Ref: 6/2020/1028/LB
Date: 12/06/2020

HISTORIC BUILDINGS AND CONSERVATION ADVICE

RE: 1-5 Park Street, Hatfield, AL9 5AT

The application is for the installation of internal wall and doorway.

**Proposed first floor plan**

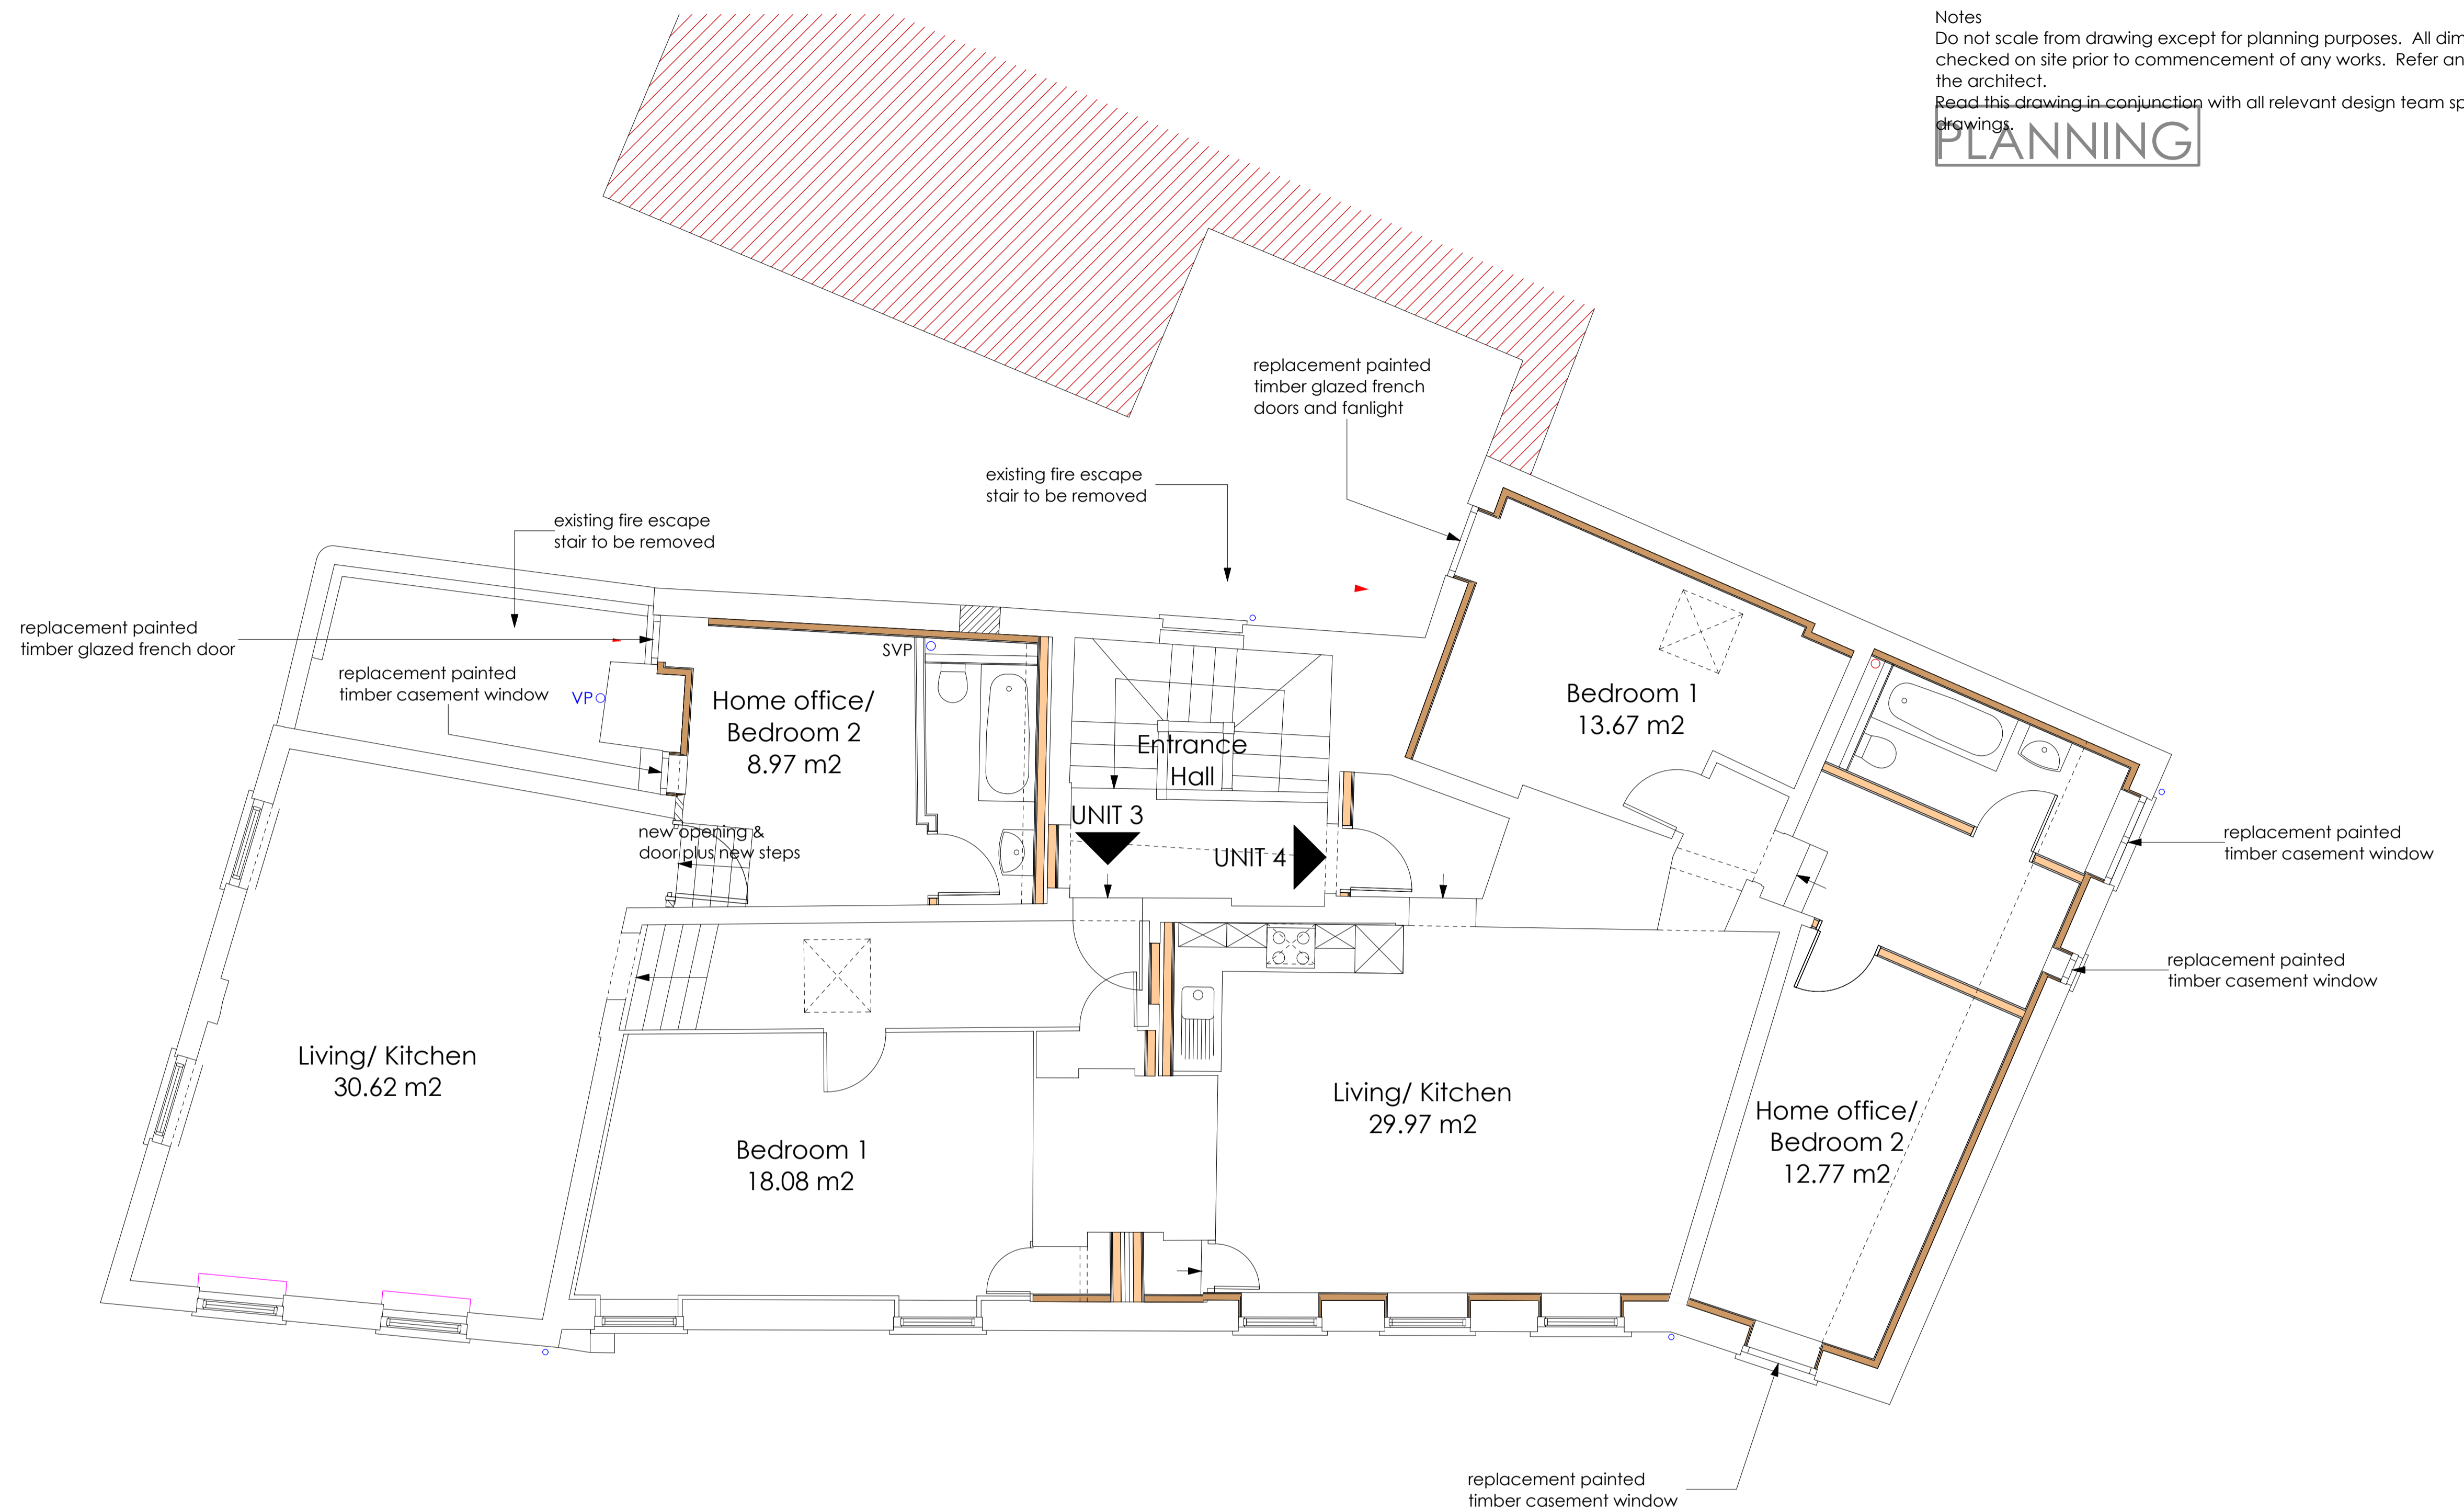
There are no objections to this proposal as it preserves fabric of high significance. The proposed doorway will see the loss of some panelling, likely 18th century in date, however, this is considered to be acceptable in this case.

PROPOSED
1st FLOOR
WALL DETAIL

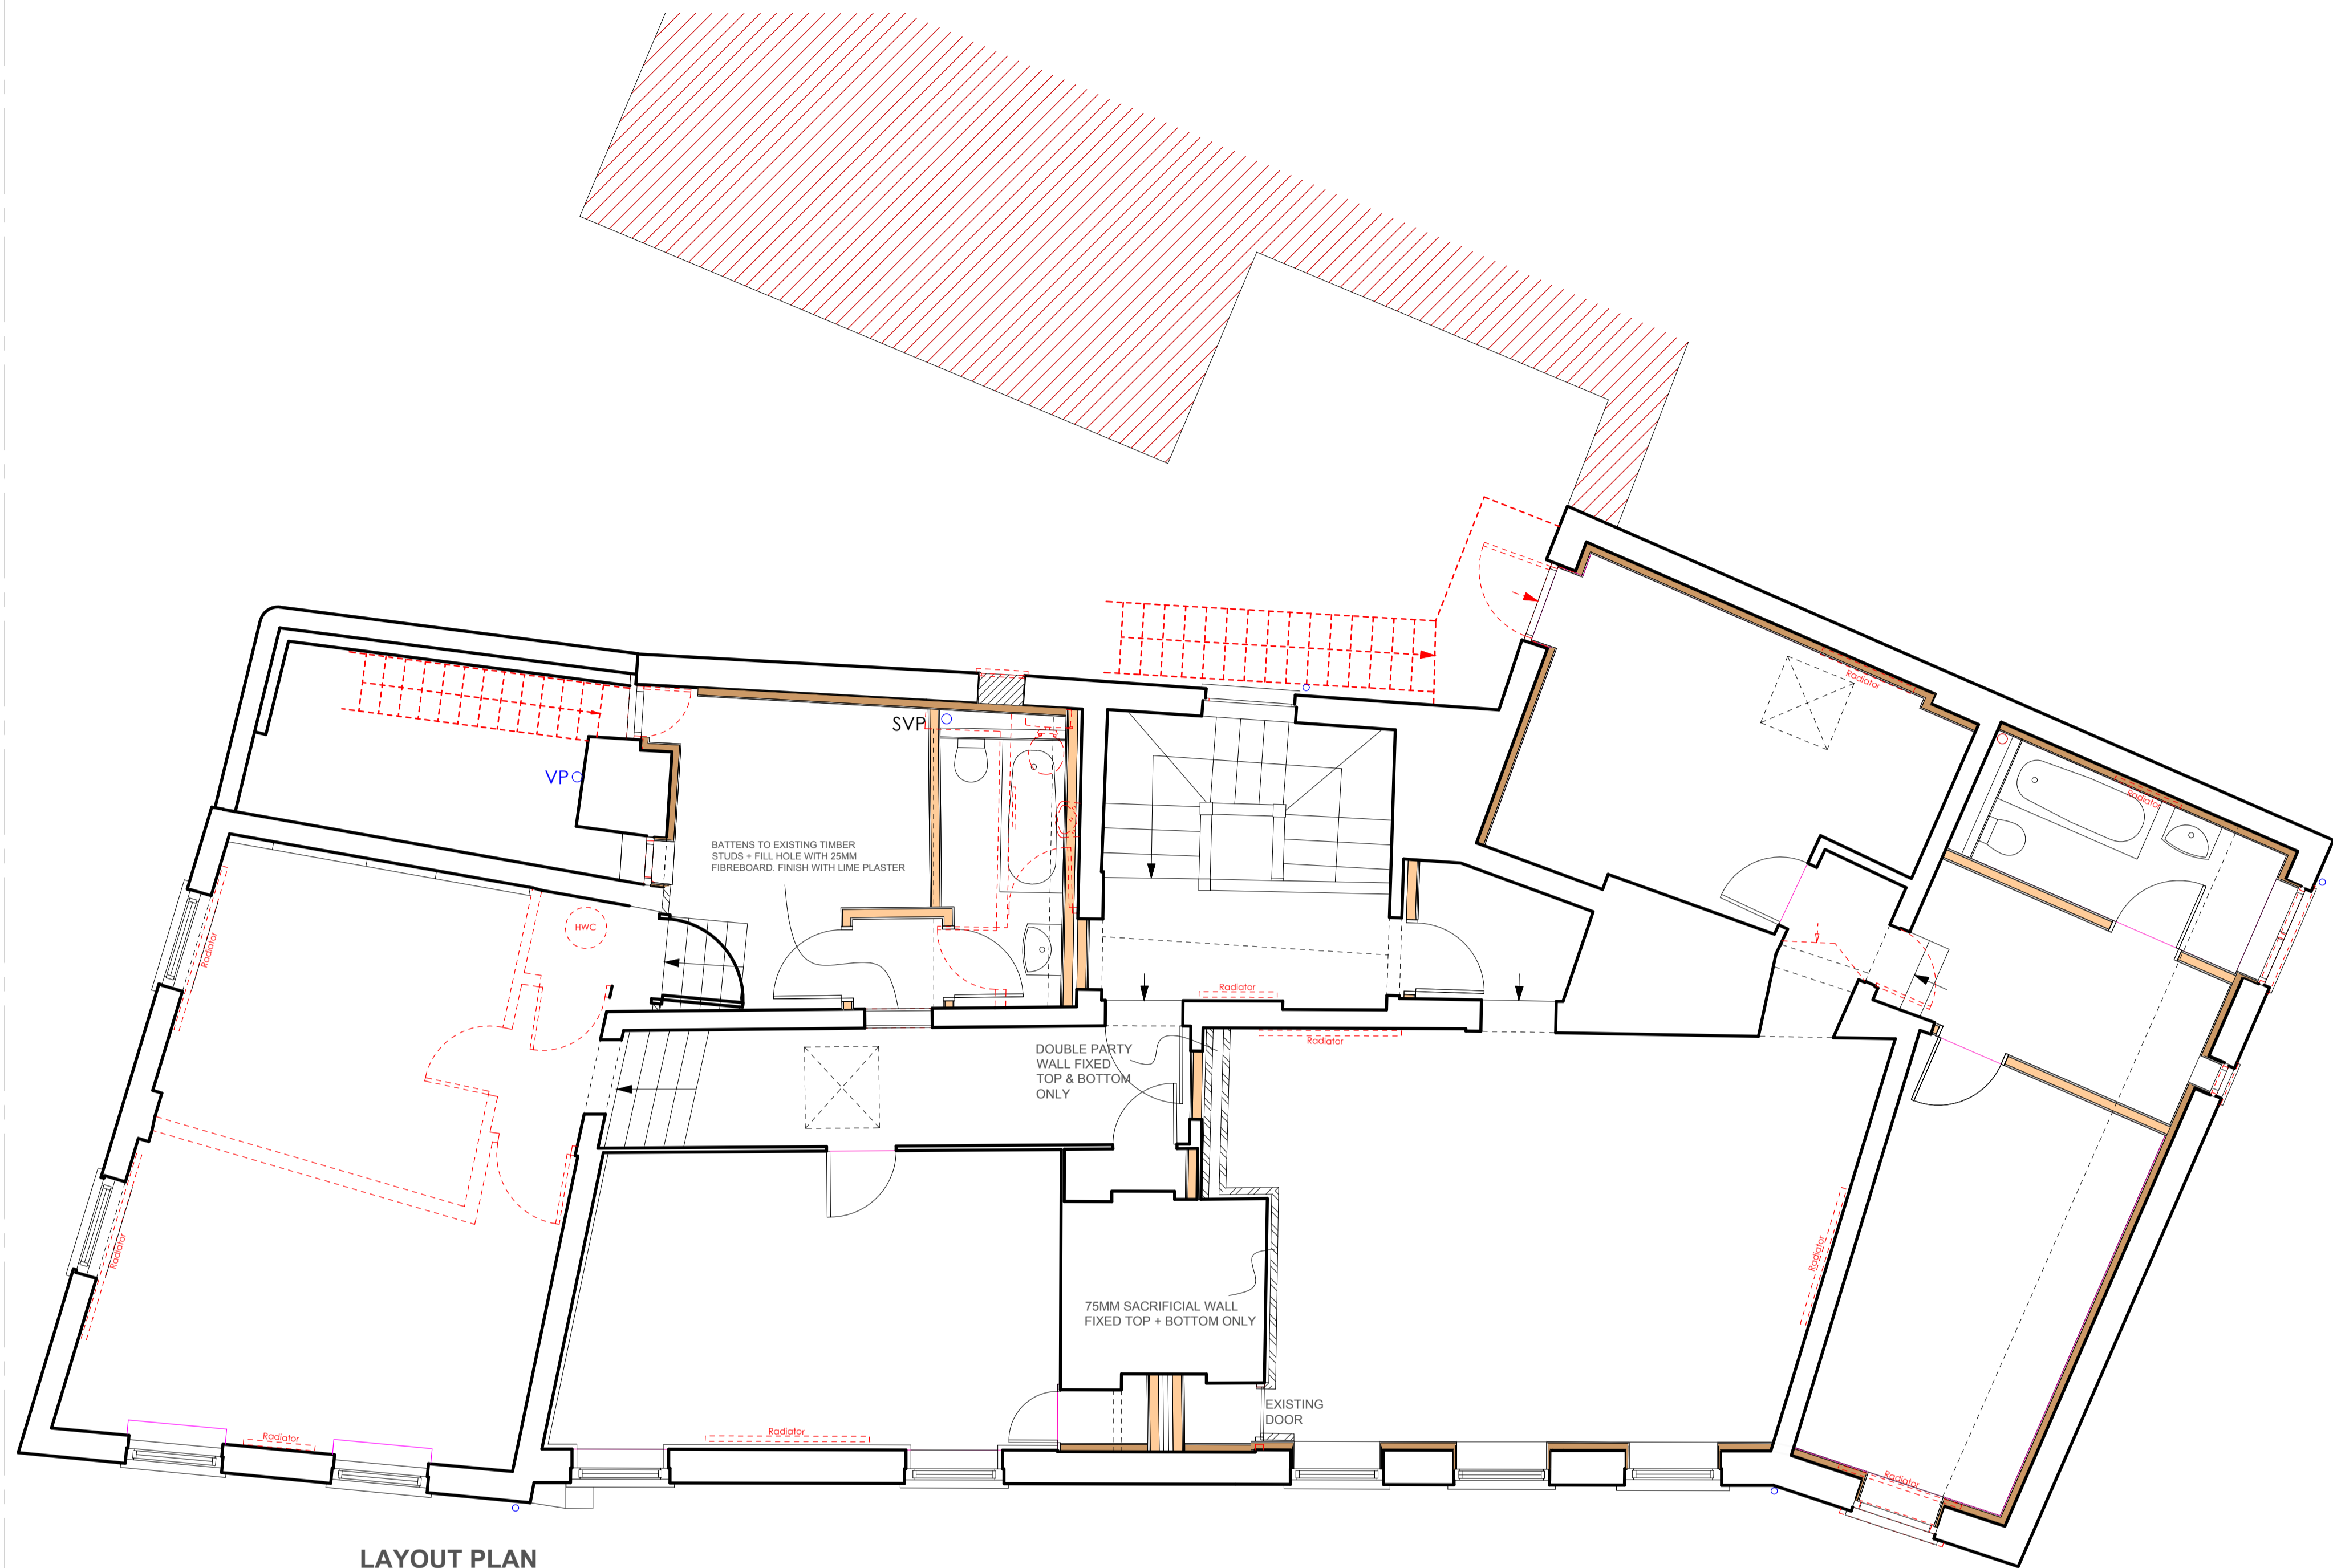
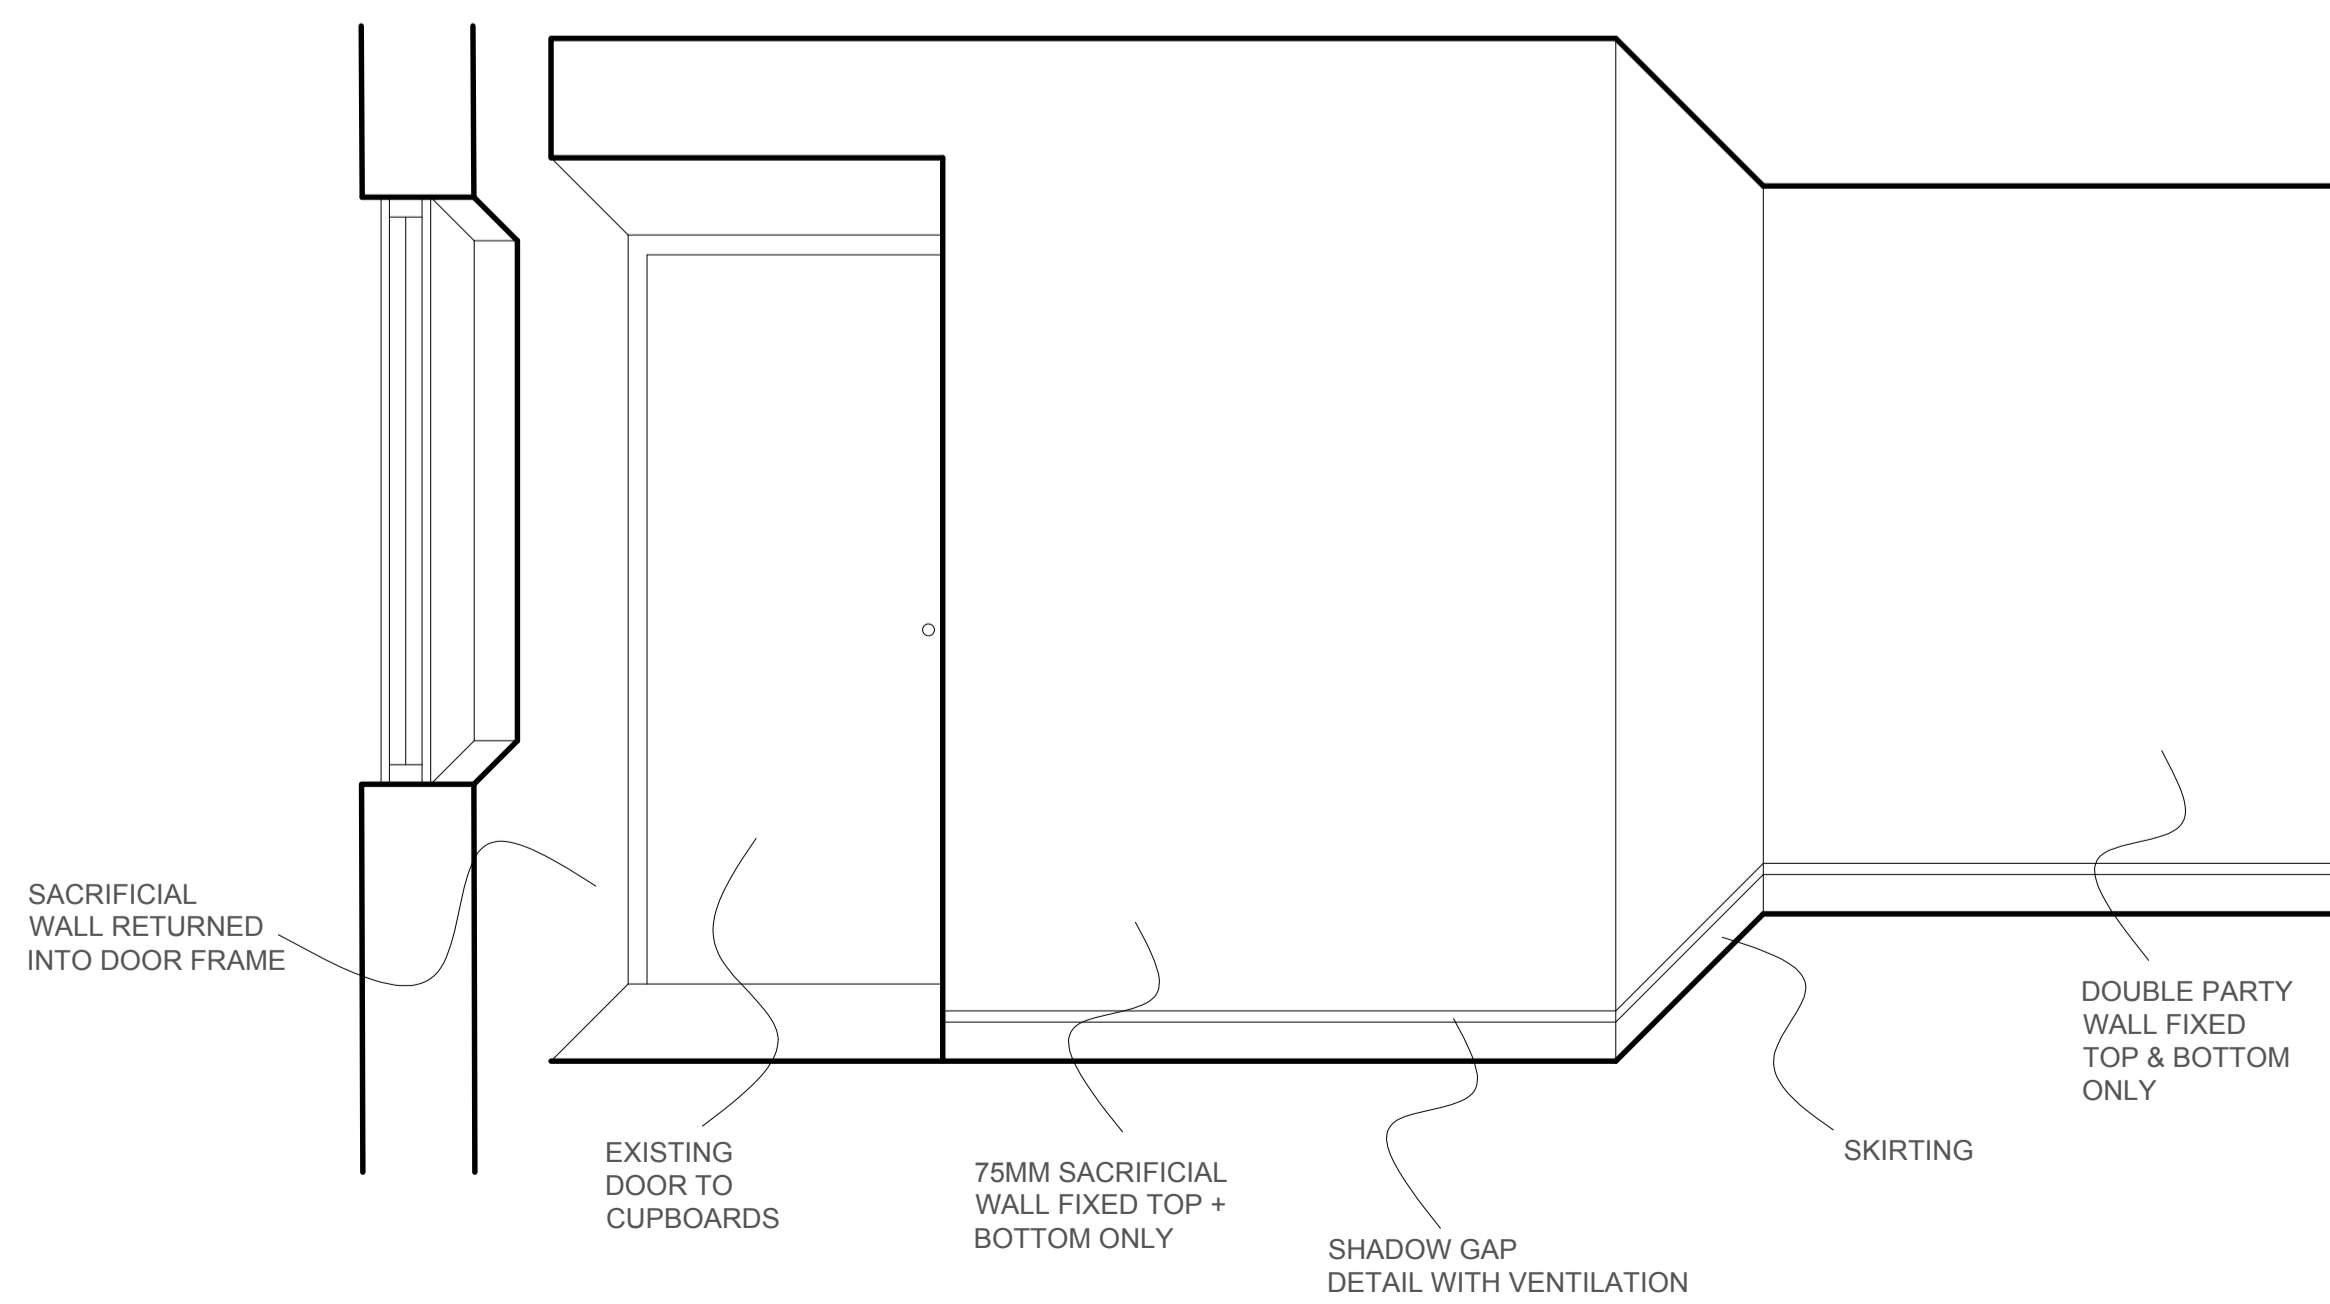
The "PROPOSED 1ST FLOOR WALL DETAIL" drawing (SP_00_01, rev. A) shows the detail of the new wall to be installed in the room at the front of the building to protect another wall painting. This is considered to be the most appropriate solution to prevent potential future damage to this particular wall painting. However, this drawing shows the previously approved first floor layout with the doorway through the corridor wall; this should be removed from the drawing and replaced with the now proposed first floor.

Whilst there are no objections to the proposed doorway, there are no details of the reinstatement of the lath and plaster in front of the wall painting. This work needs to be done with great care to

ensure the wall painting is not damaged. A breathable board, possibly a wood fibre board, may be appropriate but further details of this are required including methods of fixing.

It is suggested that drawing no. SP_00_01, rev. A is revised and additional details regarding the covering of the wall painting in the corridor are sought prior to the determination of this application.
